8th February 2013

Application for Planning Permission for Works or Extension to a Dwelling

Development Demolition of existing extension and outbuildings and new single storey extensions.

Location Well Gardens Norton Lane Aldingbourne

PROPOSED ELEVATIONS

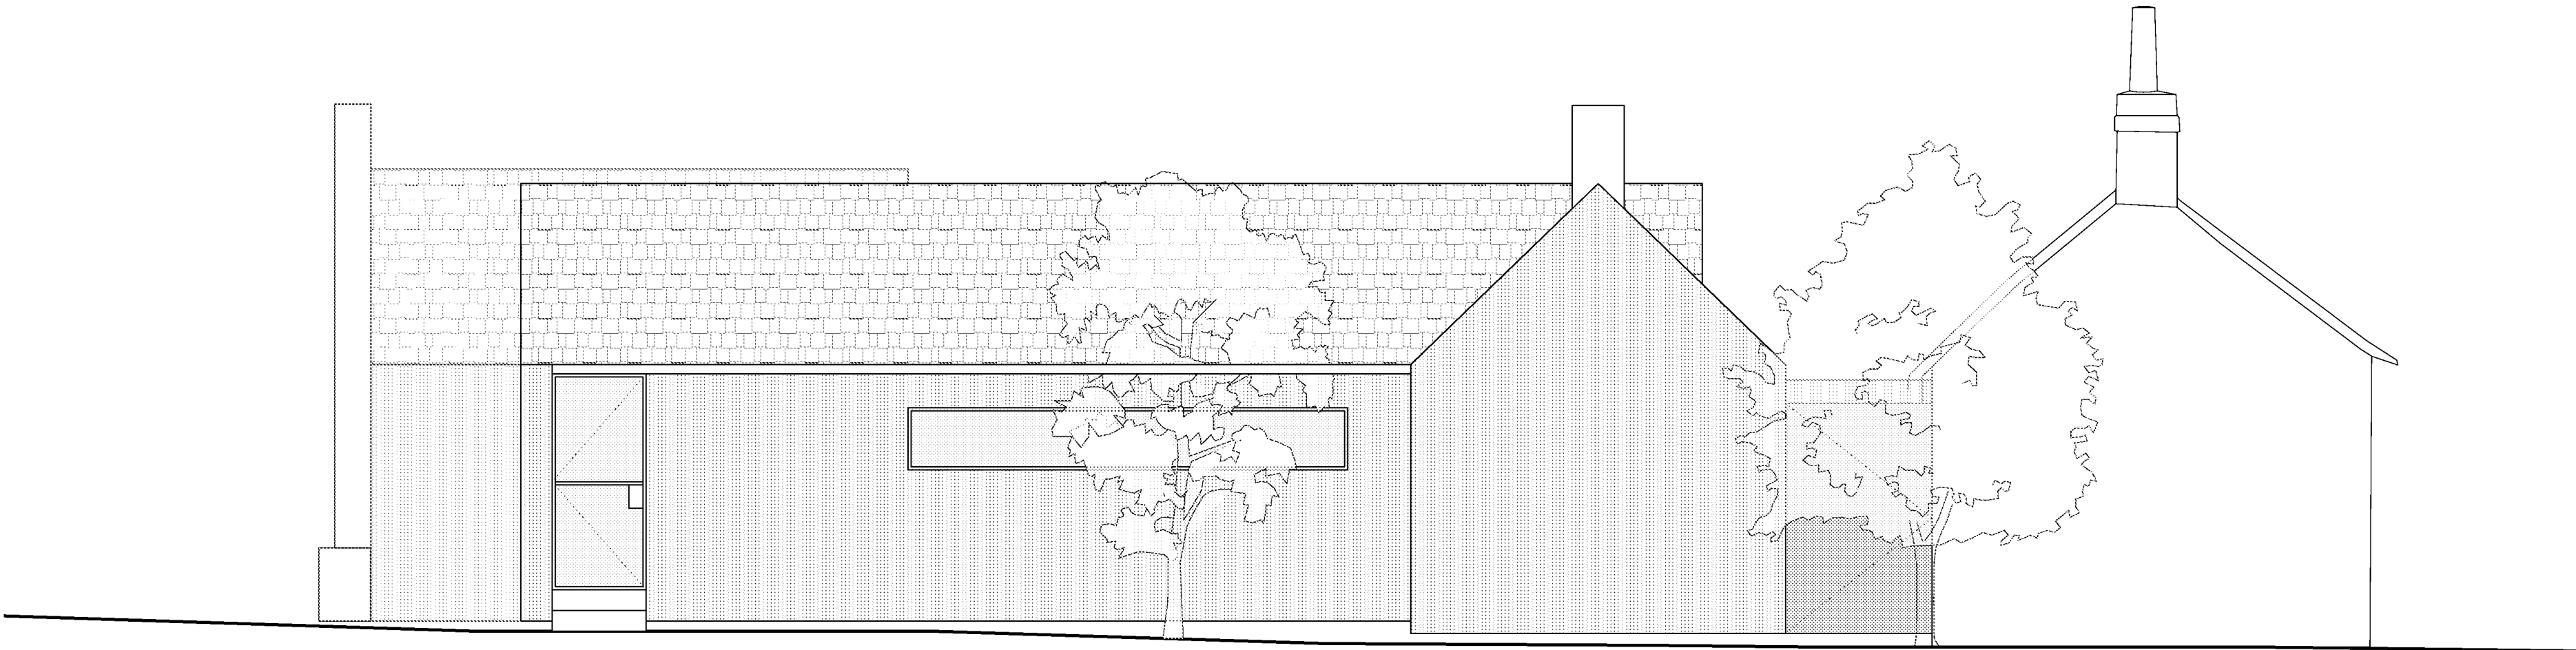
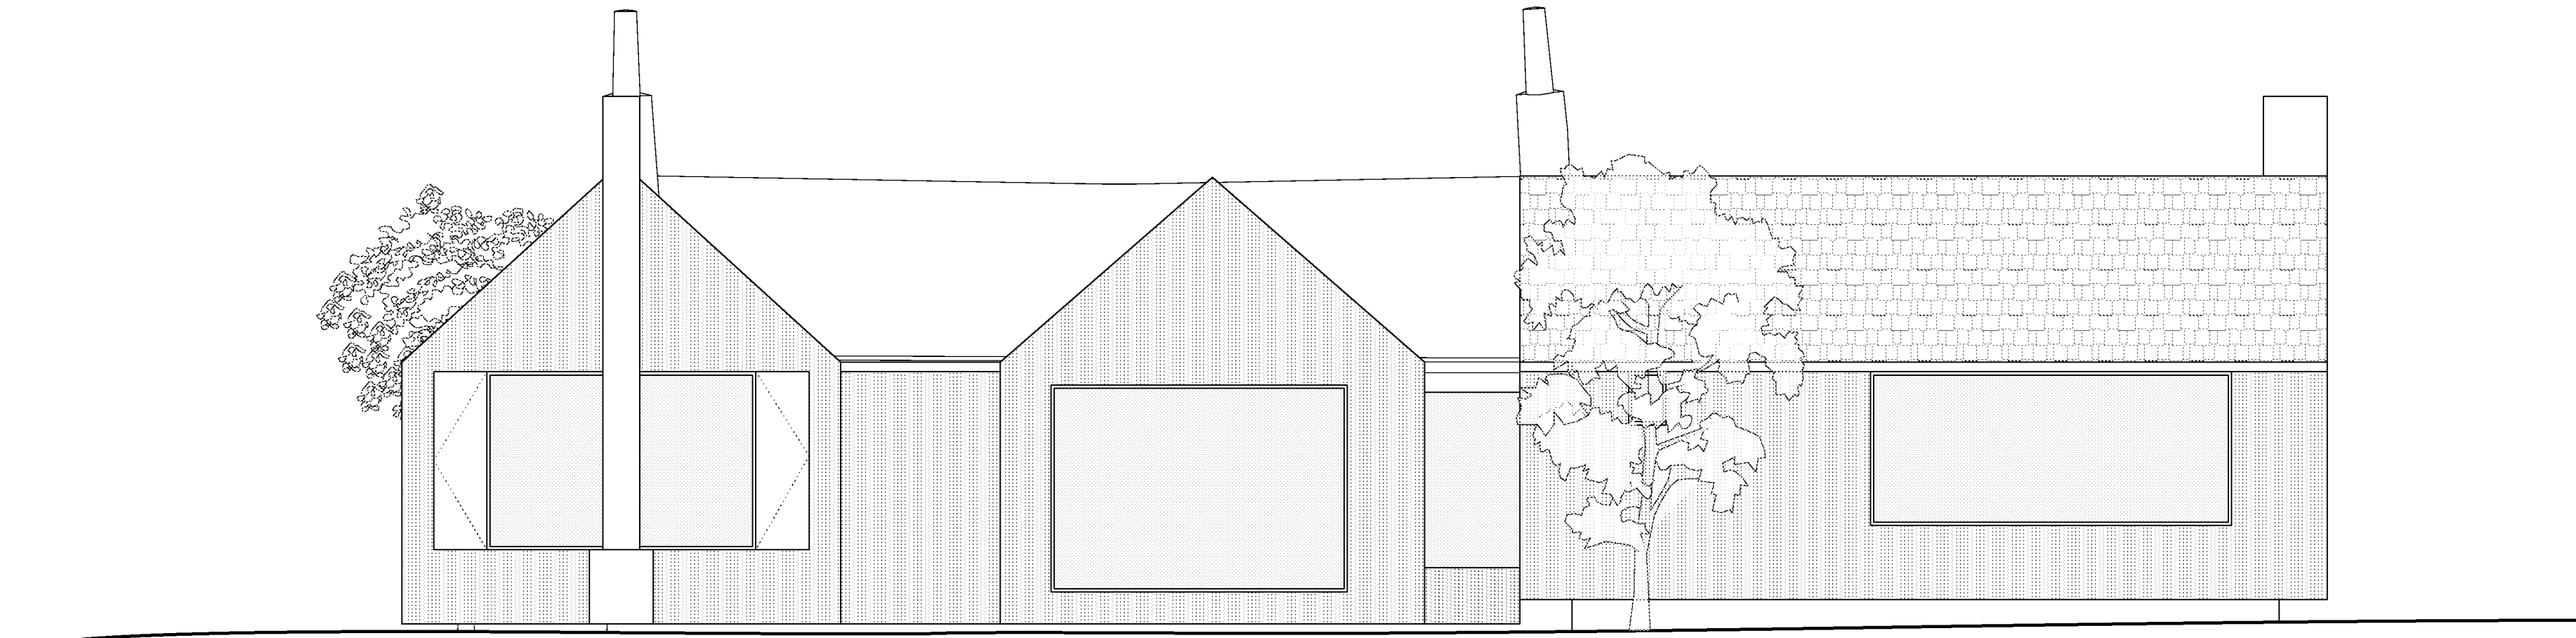
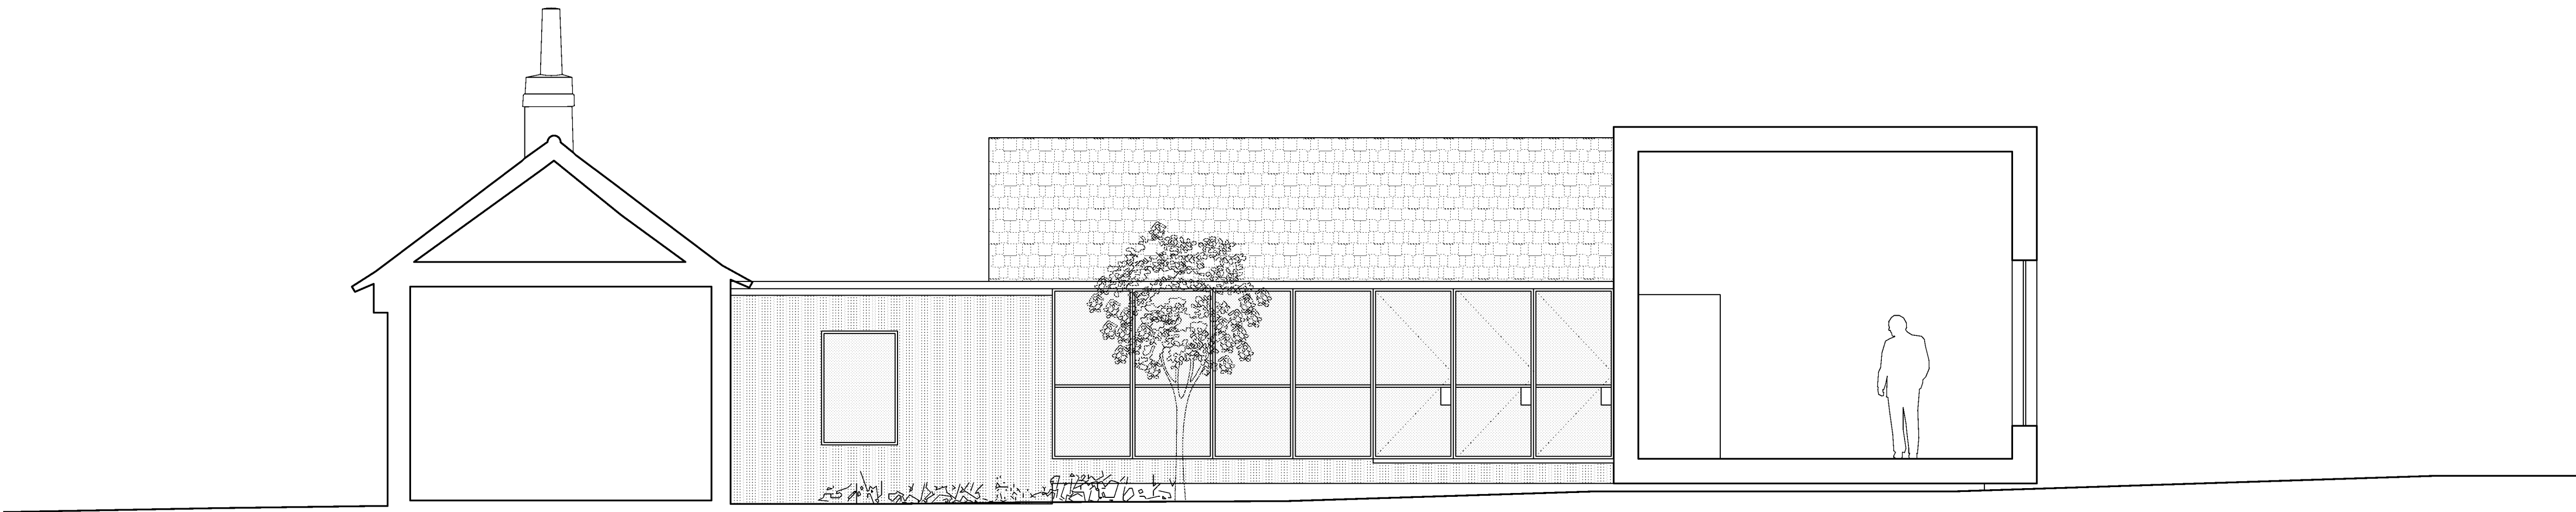
Please label the Proposed Elevations so they are consistent with the Existing Elevations (front/rear/side).

The proposed elevation (03) does not accord with the proposed side floor plan. Please amend accordingly.

The proposed elevation (02) does not accord with the proposed rear floor plan. Please amend accordingly.

EXISTING AND PROPOSED SITE PLAN

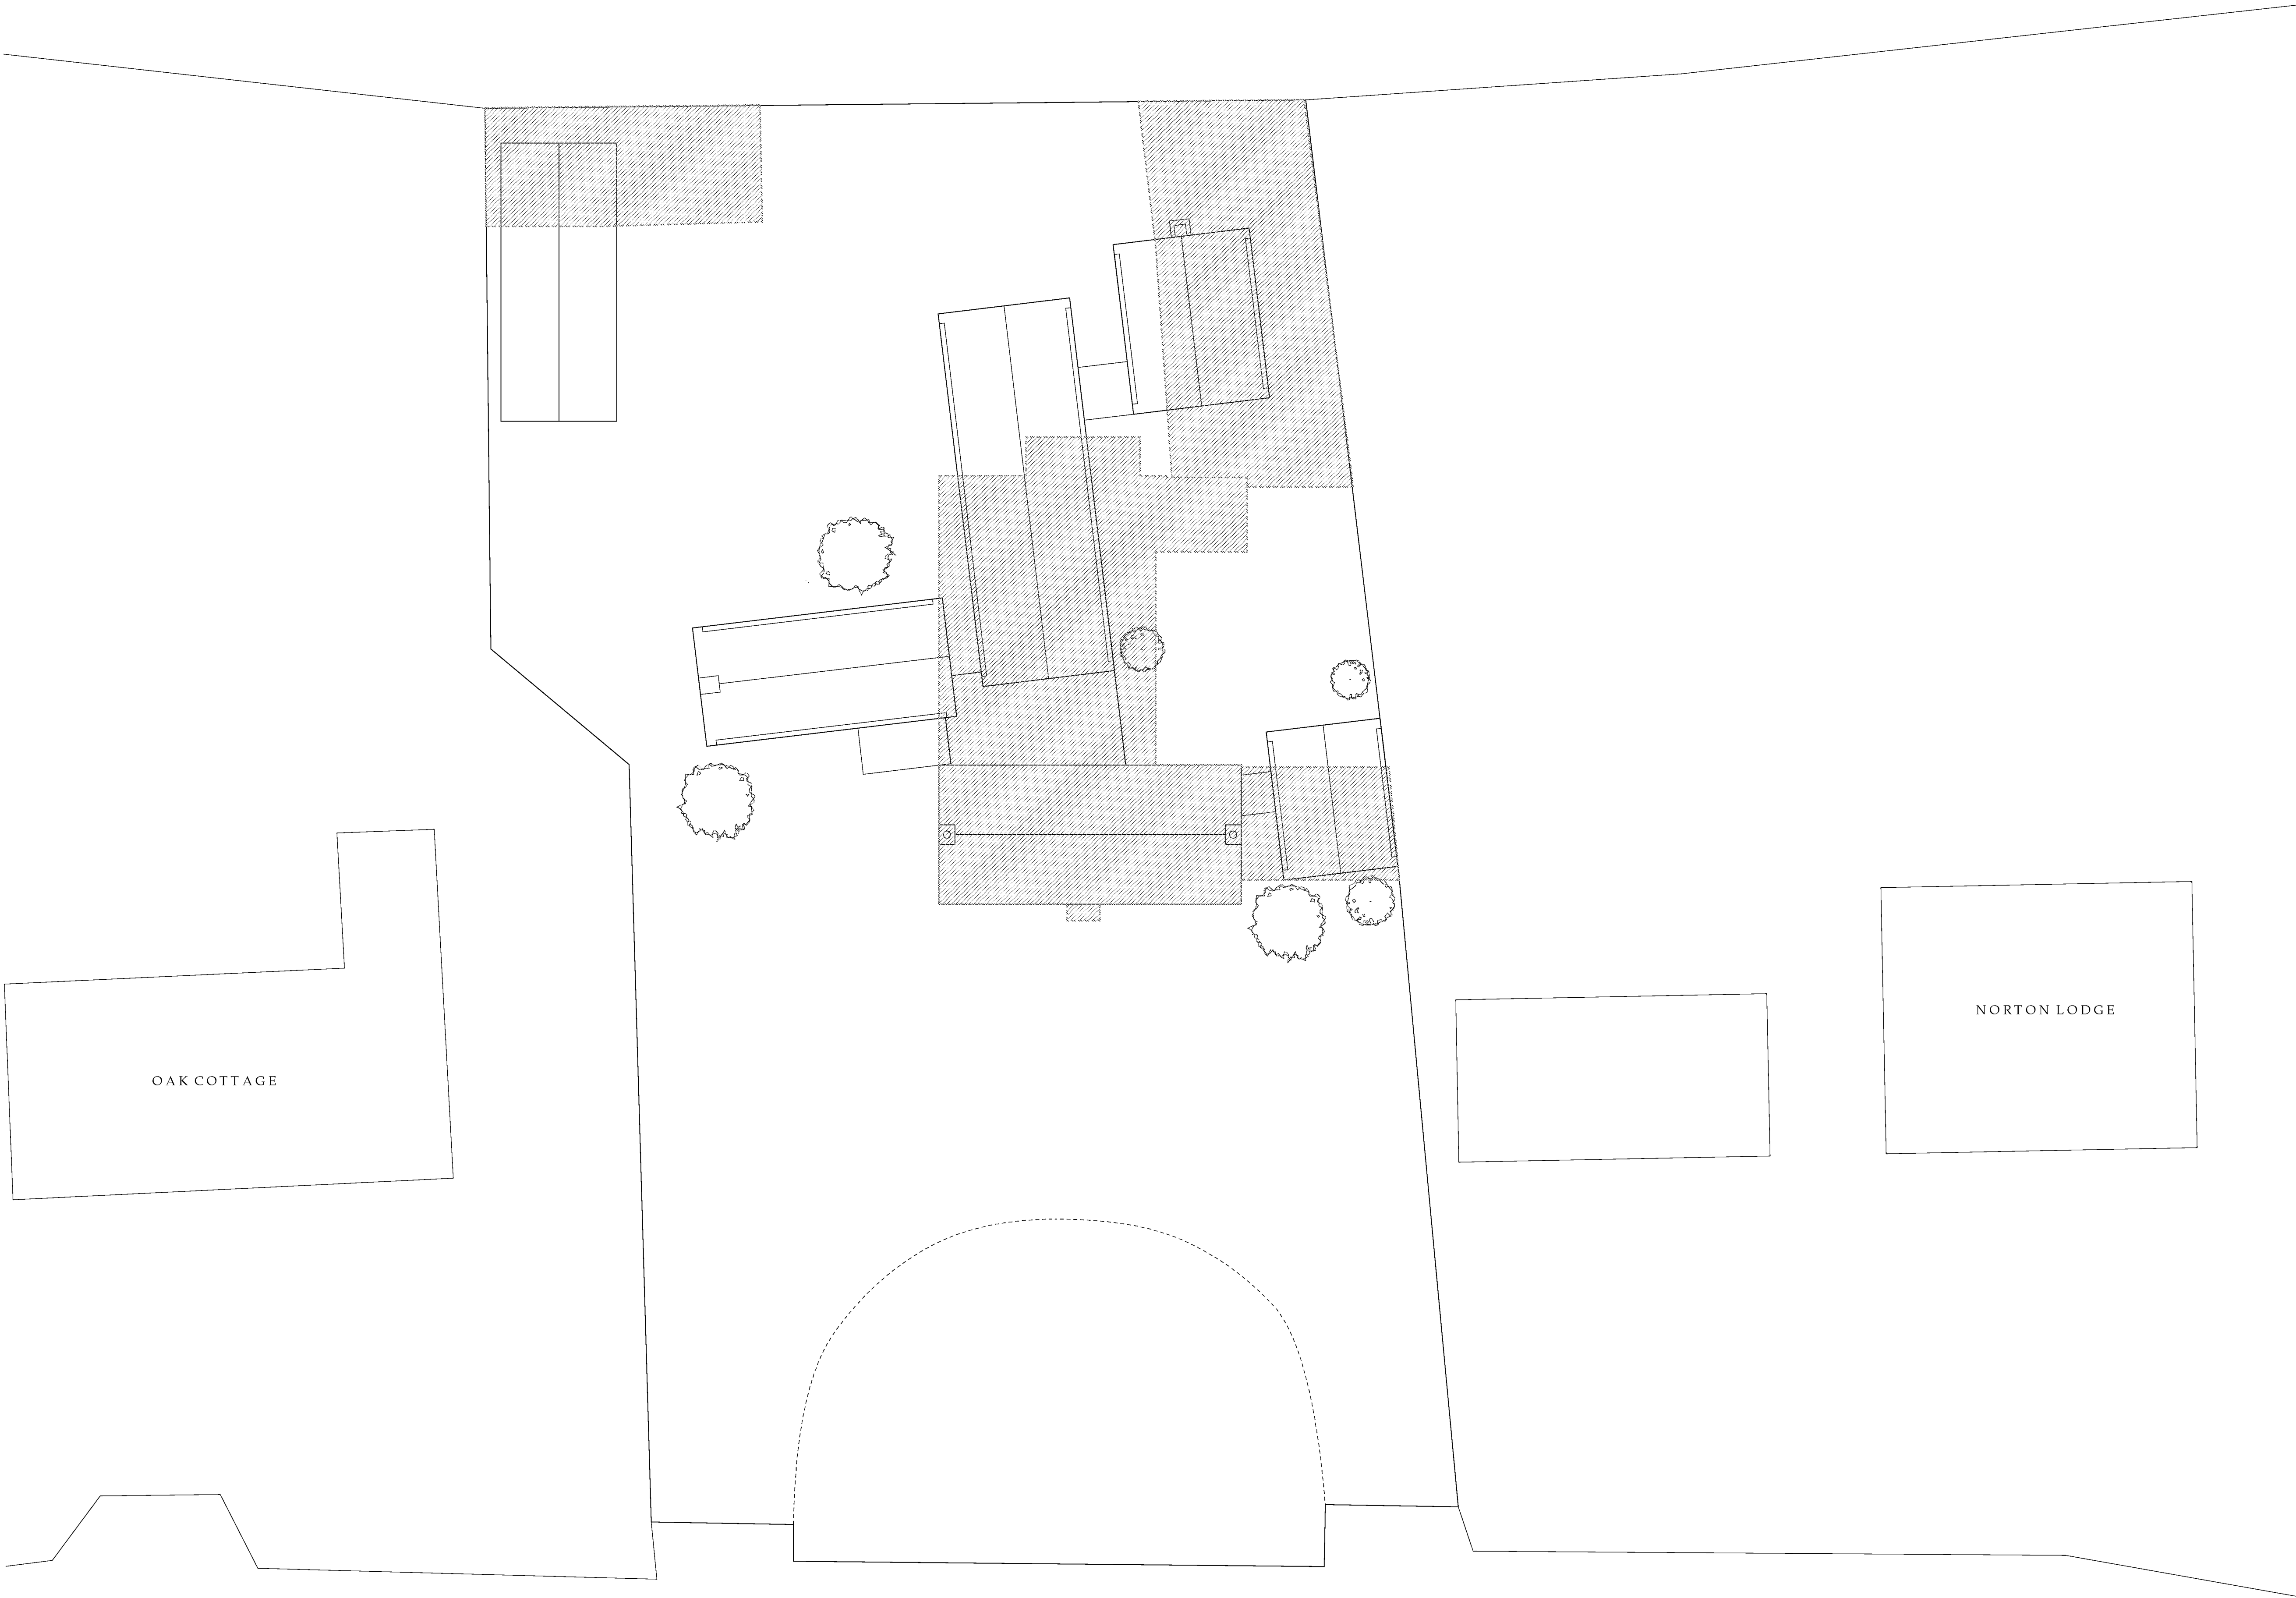
Please submit 1 electronic or 3 paper copies of a block/site plan in accordance with the guidance notes available on our website detailed below (click on National List). On the plan labelled 'Proposed Site Plan', please show the footprint of the demolished building and relabel the plan as 'Existing and Proposed Site Plan'.
